Application no: 22/02470/DISC

Location: OS Parcels 3309 And 4319 Adjoining And North Of, Milton Road, Adderbury

Lead Local Flood Authority

Objection

Client: \_\_\_\_\_  
Project: **Land North Of Milton Road, Adderbury**  
Drawing: **Proposed Drainage Strategy**

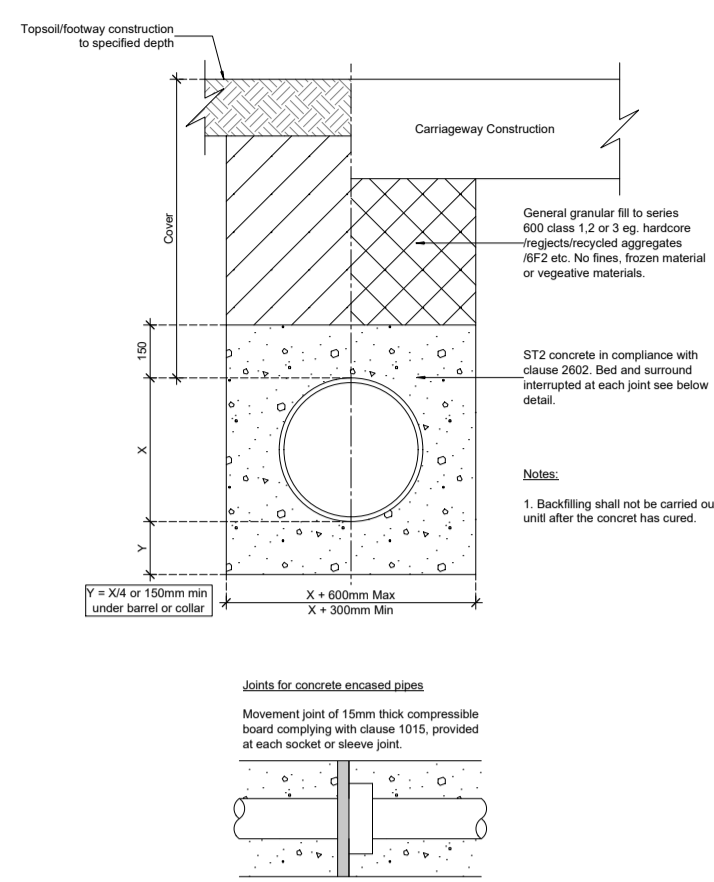
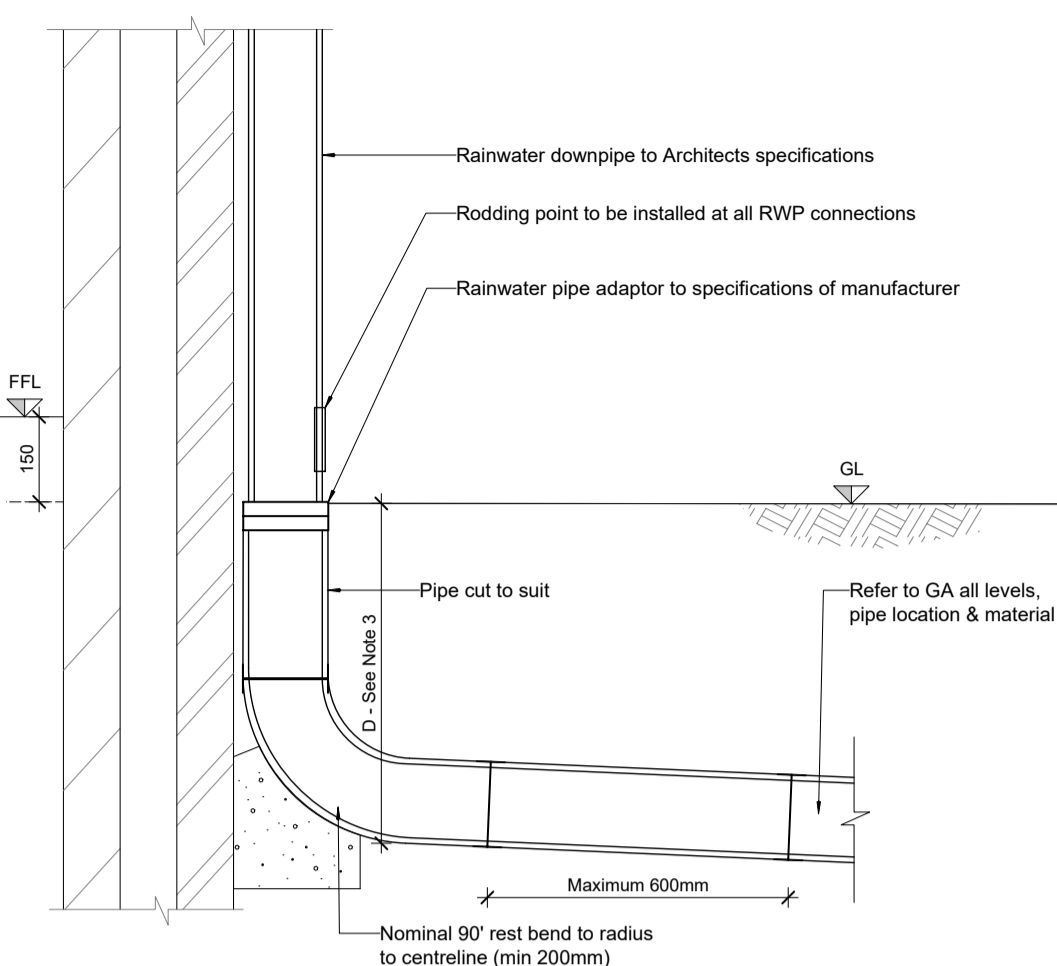
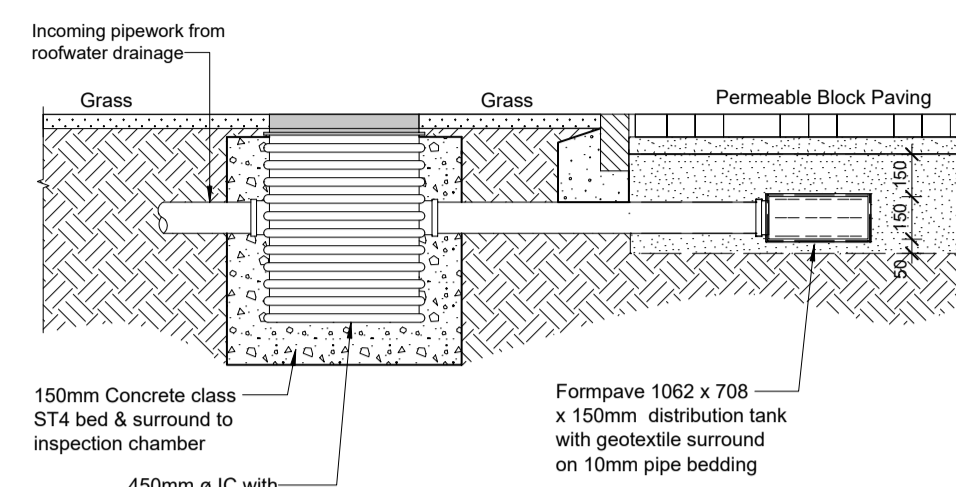
Provide detailed drainage drawing to show all drainage infrastructure and SuDS.

Ensure invert and cover levels has been provided.

The detailed drainage strategy should also show phase 1 and its proposals.

Provide exceedance plan, showing surface water run off by using flow arrows.

Ensure all surface water is kept away from structures and within the site boundary.
